Application Reference Number: 22/01559/F
Date: 13.10.2022

Thank you for passing on the recent comments from the Conservation Officer and Highways Officer. The attached and amended submitted drawings (2022.10.13_MLT_pp_04_Drawings.pdf) respond to the comments.

Changes to the initial package (submitted 06.06.2022) include amendments to:

Dwg: 1.06
Rev: 04

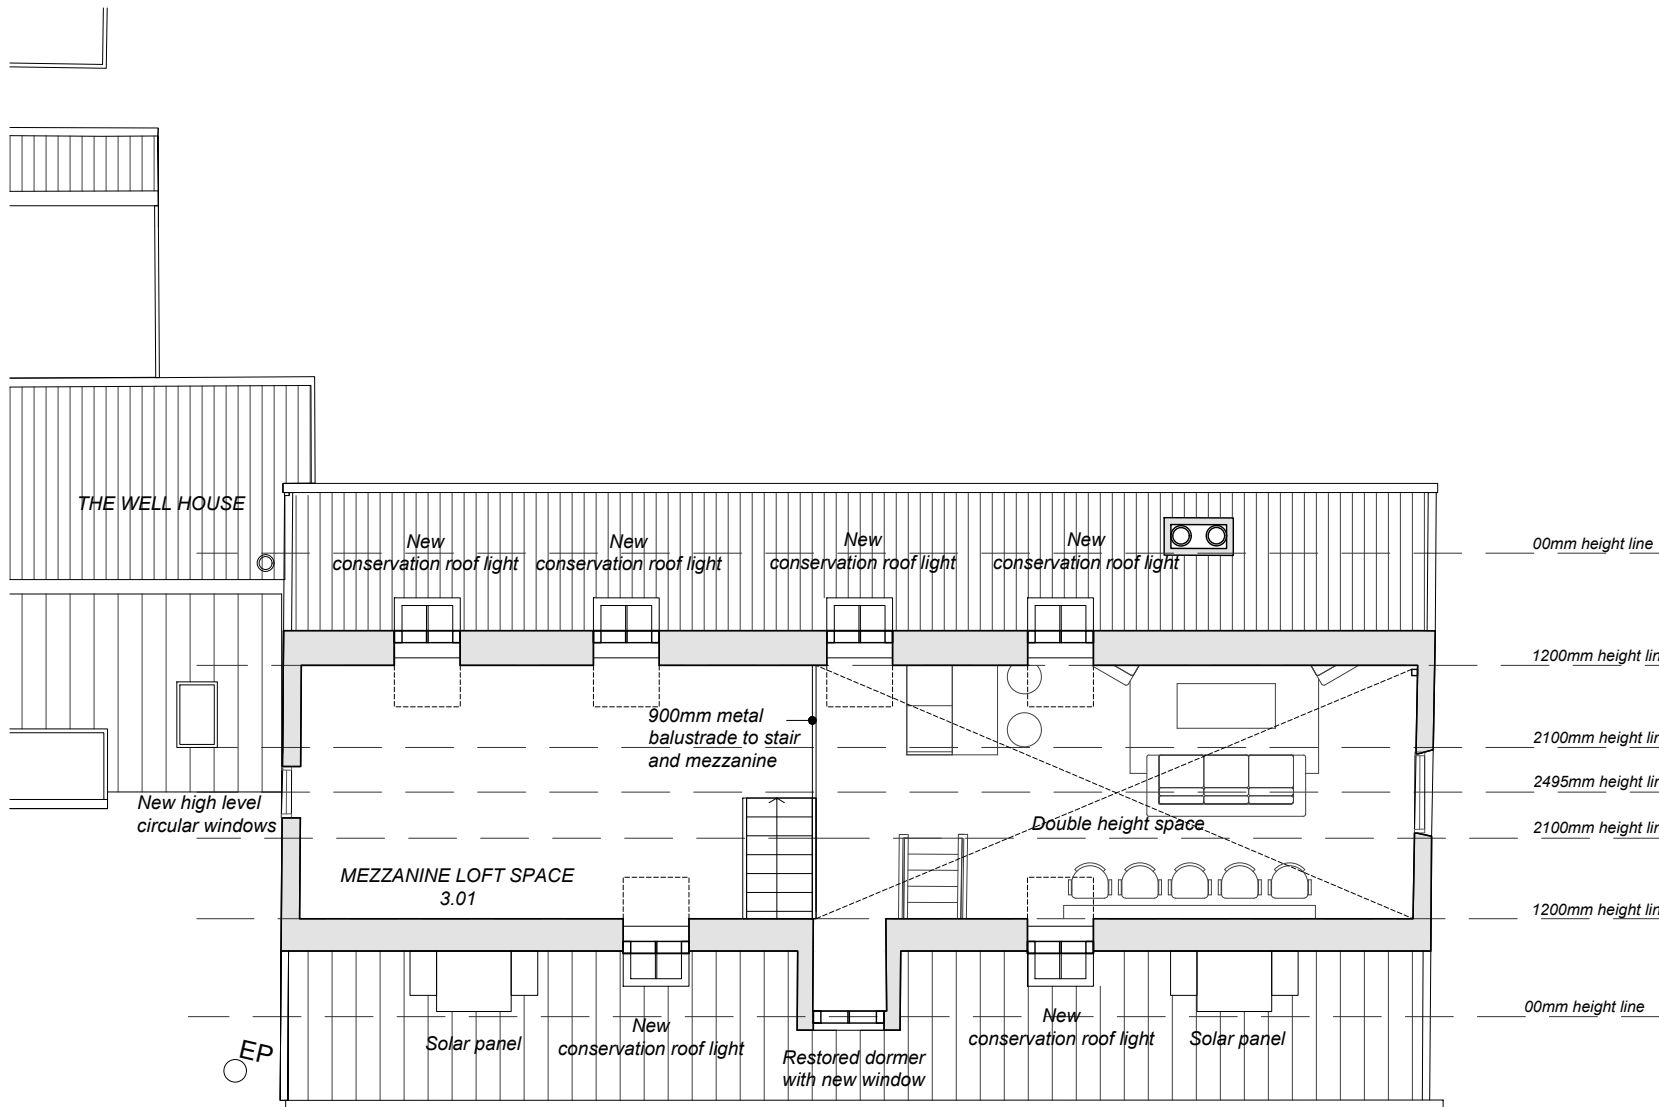
- the quantity and arrangement of conservation roof lights. This amendment was shown on the previous submission sent 27.09.22.
- the parking place. This amendment was shown on the previous submission sent 27.09.22.

Other minor changes to downpipes on the north façade, the deck on the north façade and a new mechanical ventilation outlet pipe in the roof on the north façade are included and shown in the submitted drawing package.
